Re: Objection to MP08_0244 MOD 1 Modification Request for Mixed Used Development at 23-37 Lindfield Avenue and 11 Havilah Lane, Lindfield

As a resident of Lindfield, I/we wish to lodge an objection against the proposed Modification of the subject development based on the following grounds:

1 SHADOW DIAGRAM - 21stDEC_9AM
5003 SCALE1 : 650

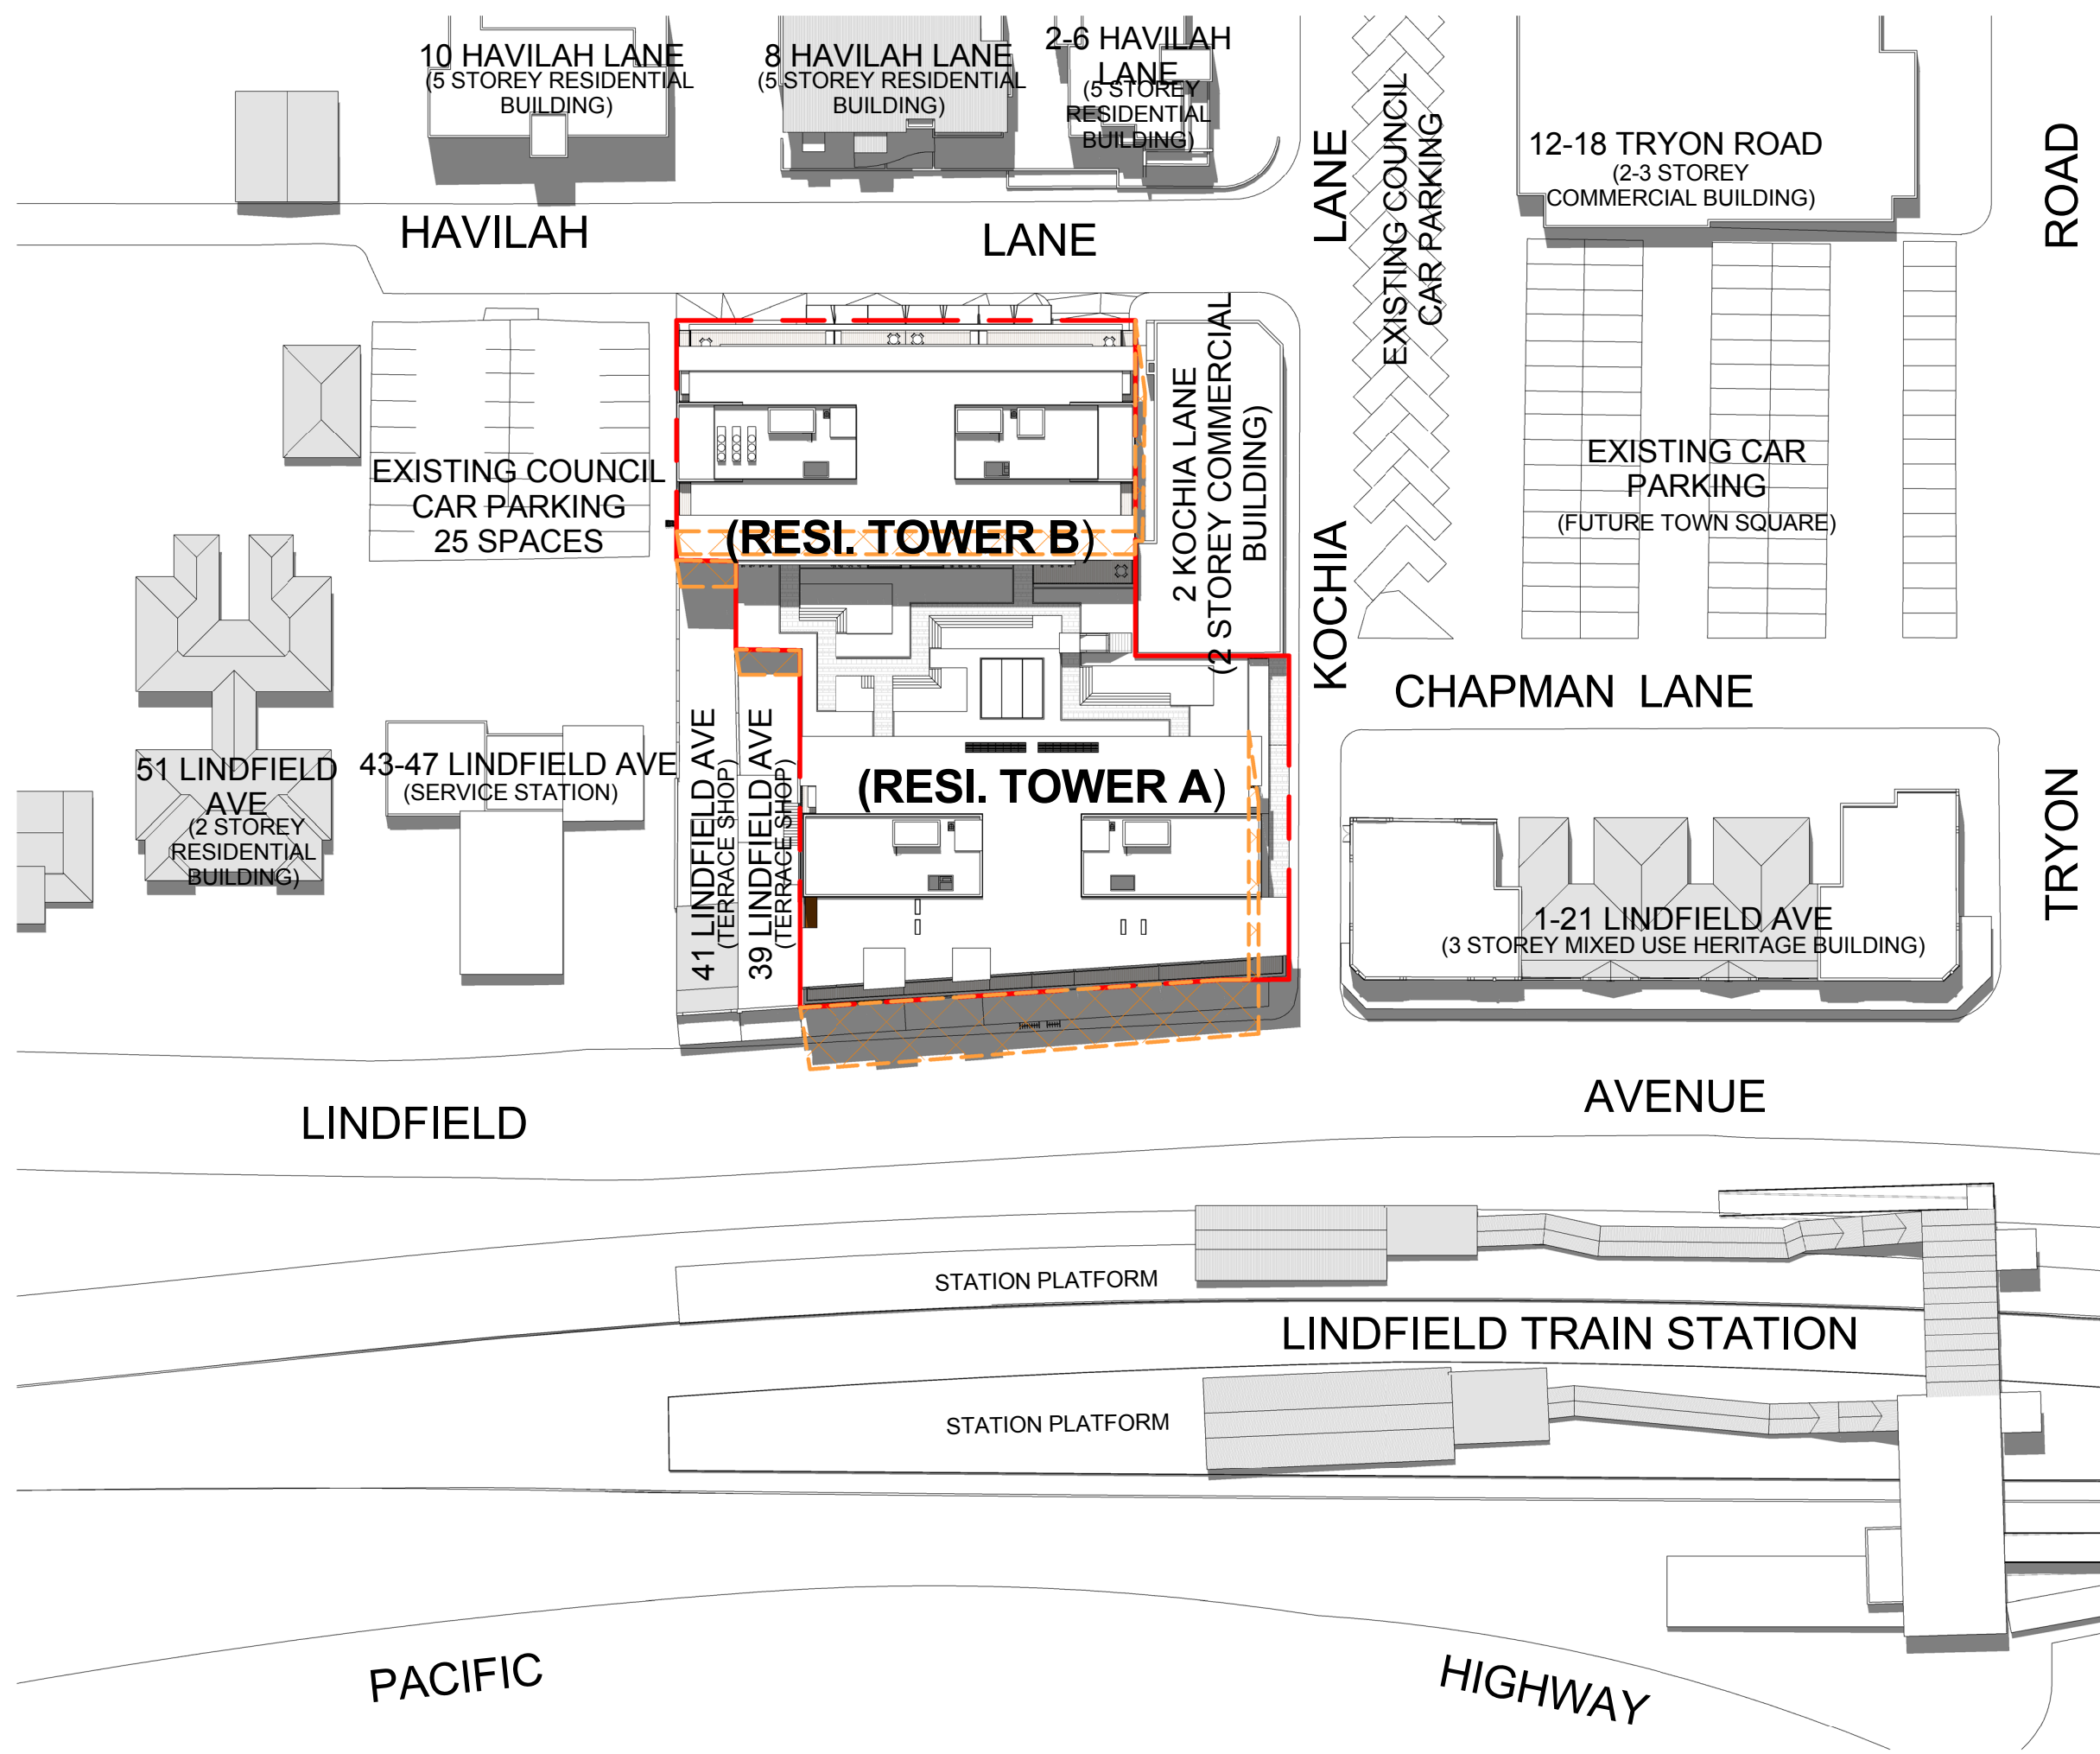
- The additional storeys create new adverse shadowing: a) for residents in the Havilah Lane apartments, particularly after 3pm b) for the popular outdoor café and central Lindfield hub area at 12 Tryon Road in afternoons, particularly in winter and c) for all commuters on the city bound Lindfield rail platform. Instead of 50% of the year as approved, it will now be in shadow in the mornings 75% of the year
